Planning Application Reference No.: 3/2026/0531

Address of Development: Brathay, 2 Whittam Crescent Whalley BB7 9SD

STREET SCENE
Scale 1:50

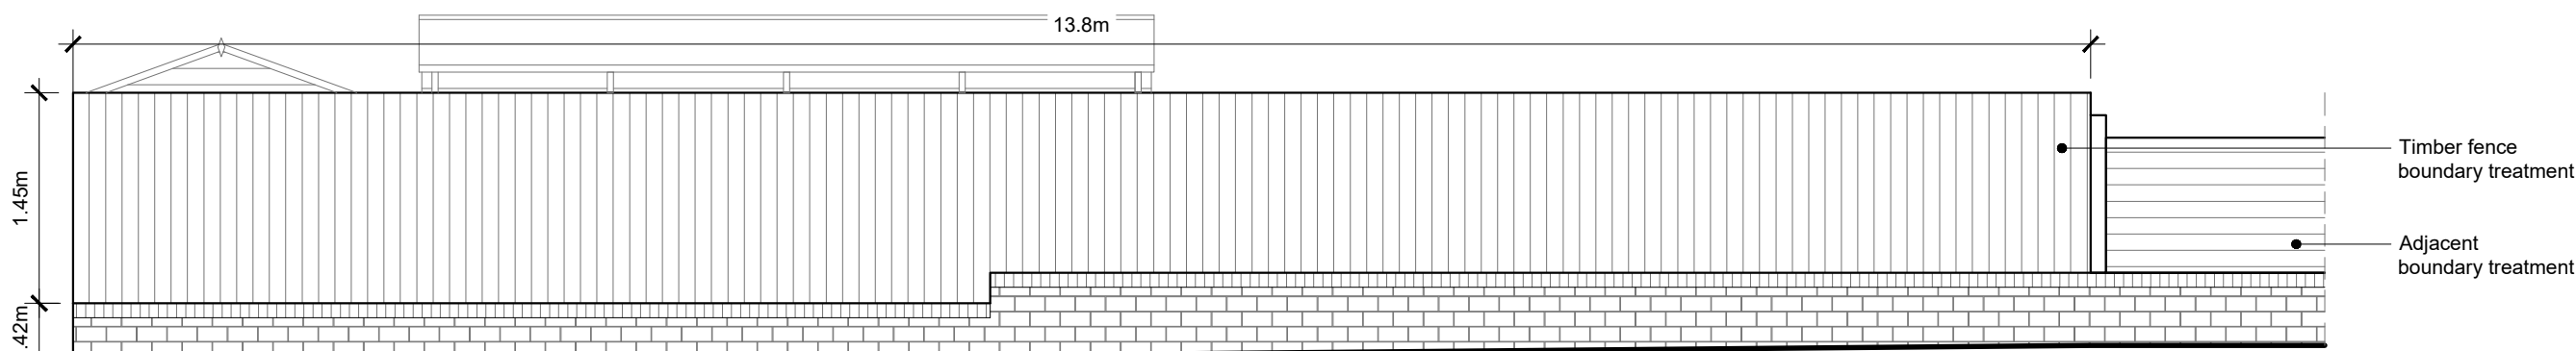
Comments: Timber fence & outbuilding - shed not in keeping with surrounding properties.
